Meath Co. Co. Reference: 21-424

RE: *"The development consists of the construction of an extension to an existing wastewater treatment plant (WWTP) where the works include:*

Subject: Response to Submission by IFI

04 Tideflex® Diffuser Valve for Effluent Discharge to Water Body
NTS

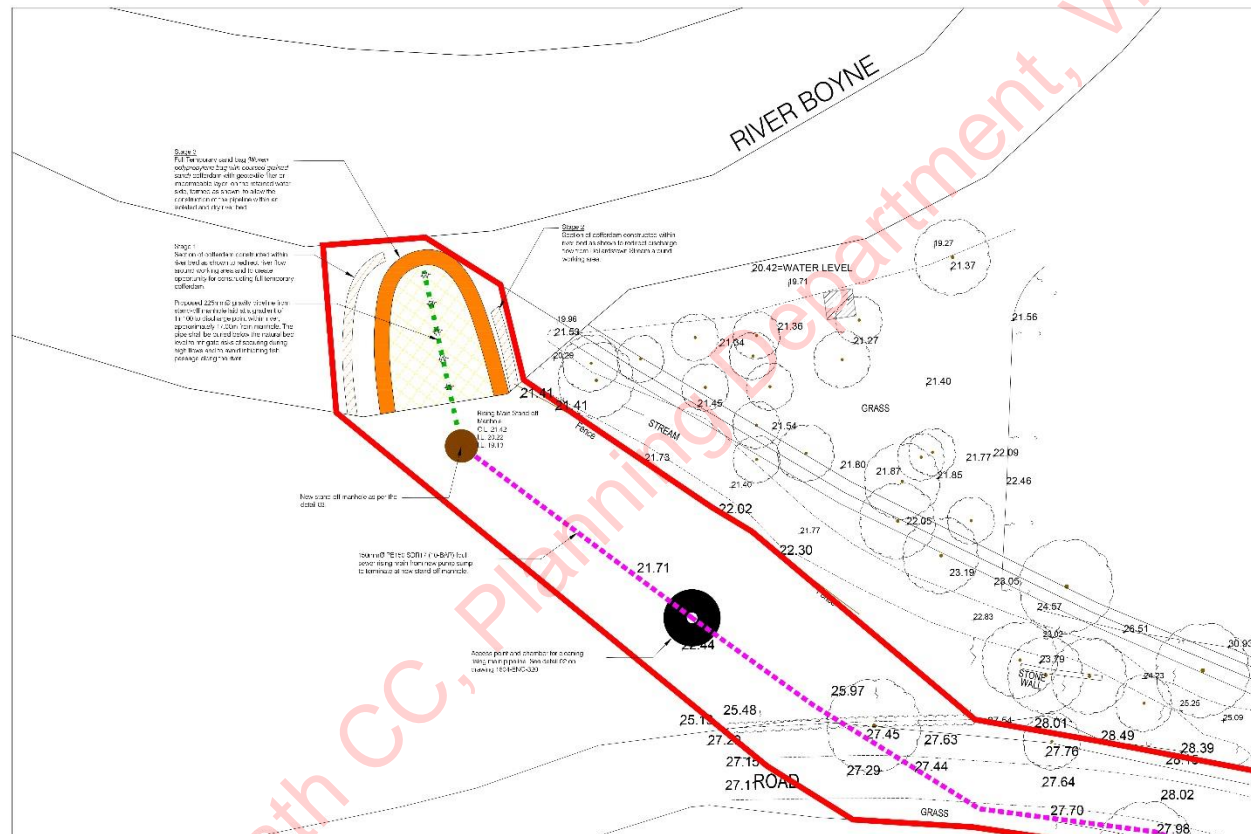
Details of the exact details of the discharge pipe at the discharge point have not been provided. Is it a point discharge, a diffuse discharge, how far into the river will it go, what position in the river, will it disturb substrate, spawning beds, etc? Such details are not known and included in the NIS. Therefore, it is not possible to conclude what the potential impacts of the works are on the Qualifying interests of the SAC and Meath County Council may be obliged to refuse consent.

We are concerned about the integrity of the river bank where the stone wall is planned to be located. Any construction works may result in the undermining of this bank, resulting in the initiation or acceleration of erosion.

or nursery habitat. In addition, there is no optimal salmon spawning or nursery habitat. In addition, see revised plans that show the location and design of the proposed outfall location

Please see Outline Construction & Environmental Management Plan as RFI Attachment 3.2. In addition, please see revised plans for the outfall location that remove the requirement for a stone wall at the riverbank.
